Arun District Council
Arun Civic Centre
Maltravers Road
Littlehampton
West Sussex BN17 5LF
Planning & Building Control General Enquiries
Tel: (01903) 737756 Fax: (01903) 730442
Dx: 57406 Littlehampton
Minicom: 01903 732765
e-mail: planning@arun.gov.uk
website: www.arun.gov.uk/planning

7th June 2021

Application No: R/108/21/PL
Site Address: 117 Sea Lane Rustington BN16 2RU
Description of works: Demolition of two dwellings and the construction of 3 No. 3-bed town houses and 7 flats. This site is in CIL Zone 4 and is CIL Liable as new dwellings.

DRAWING TITLE 3D Views

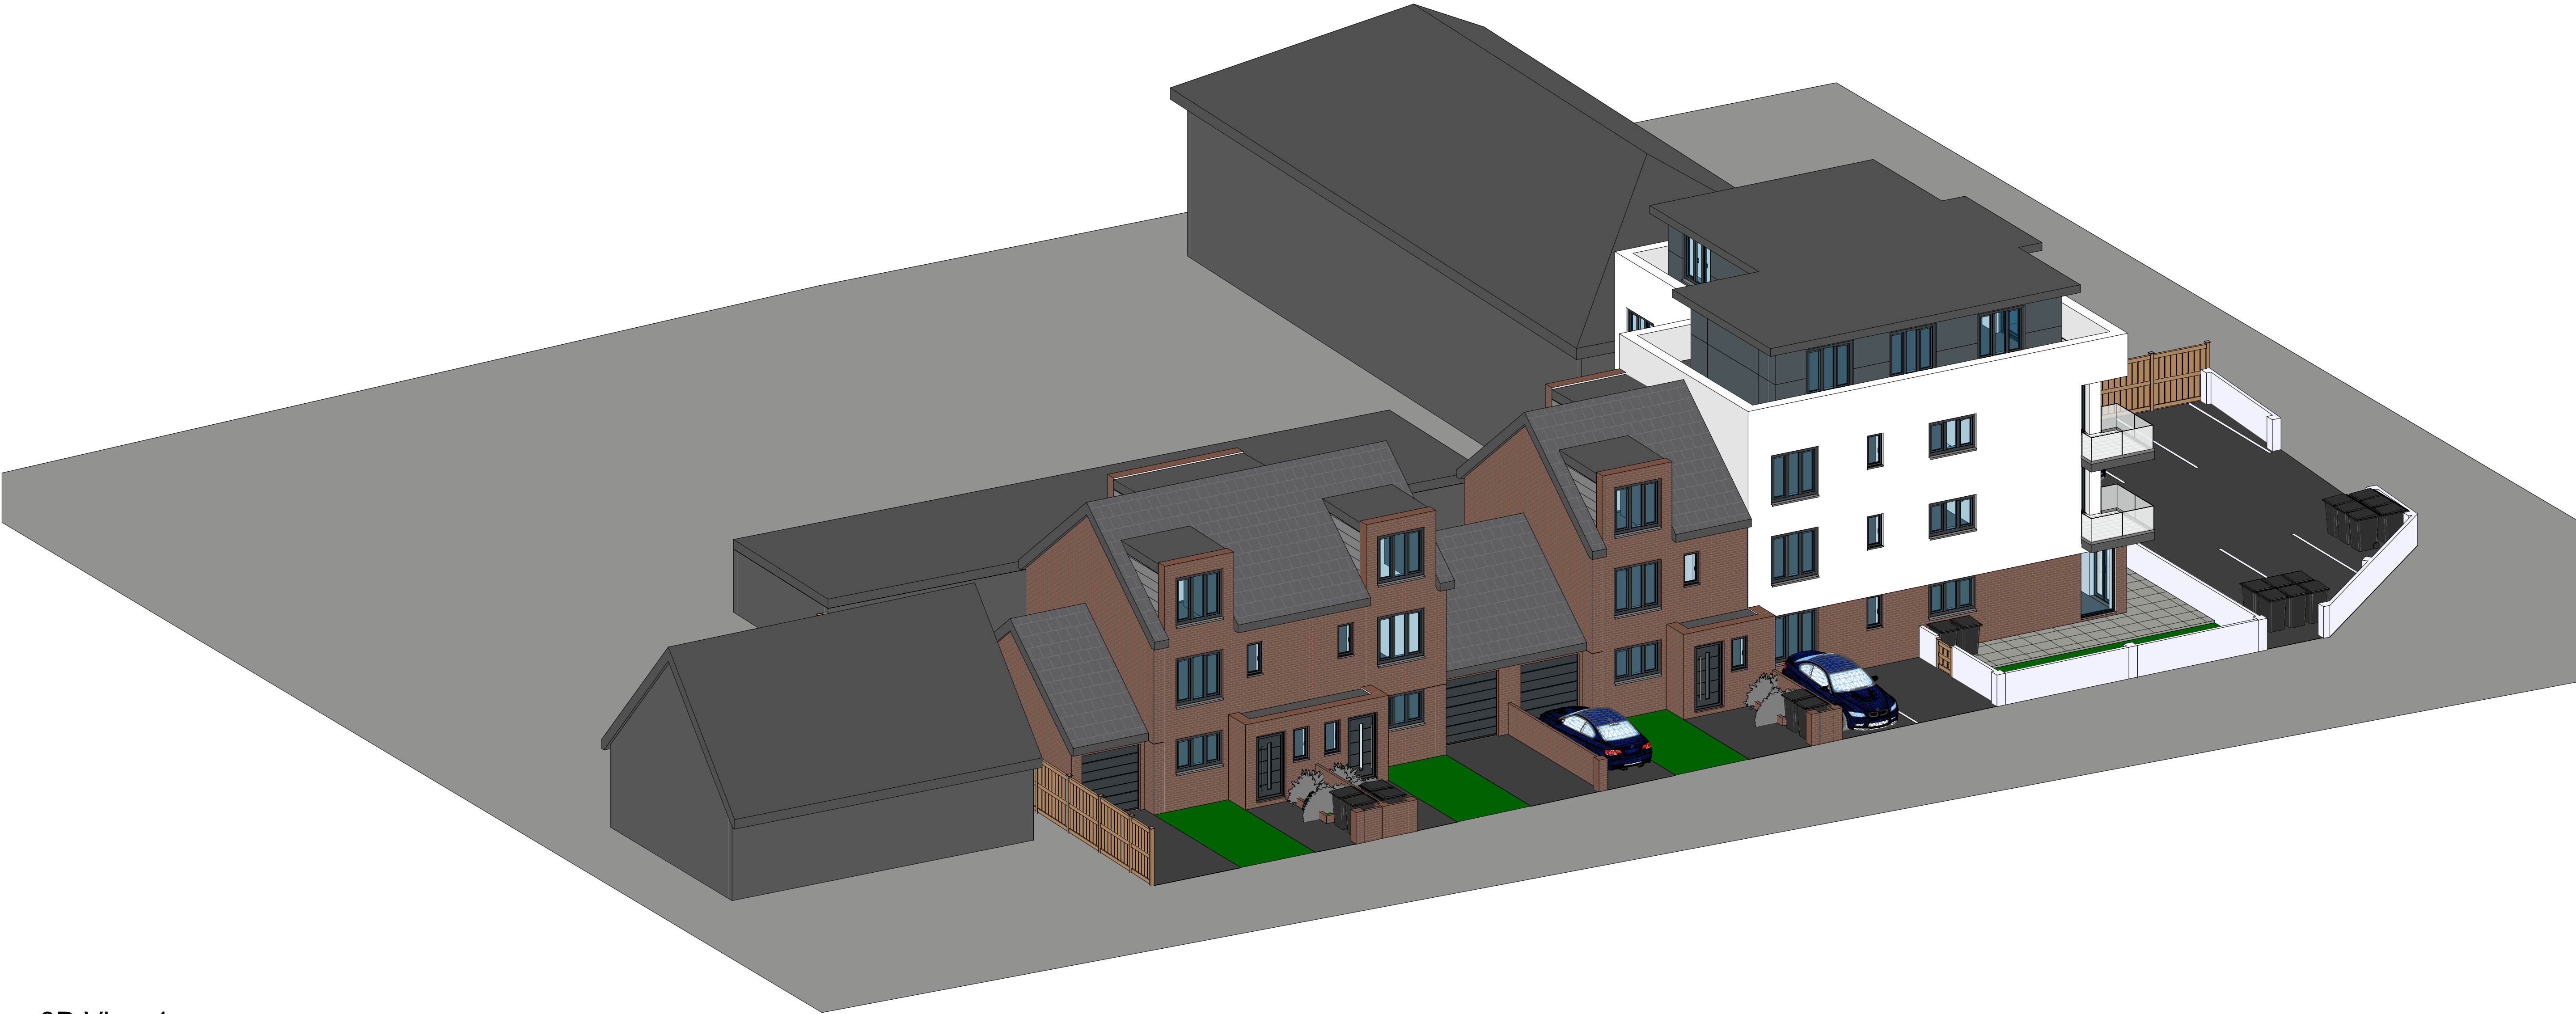
The 4 storey flat topped block proposed is totally out of character in terms of appearance as all Shaftesbury Road and Sea Lane residential buildings have tiled pitched roofs. I am also concerned that the height of the proposed new building may result in the lose of daylight
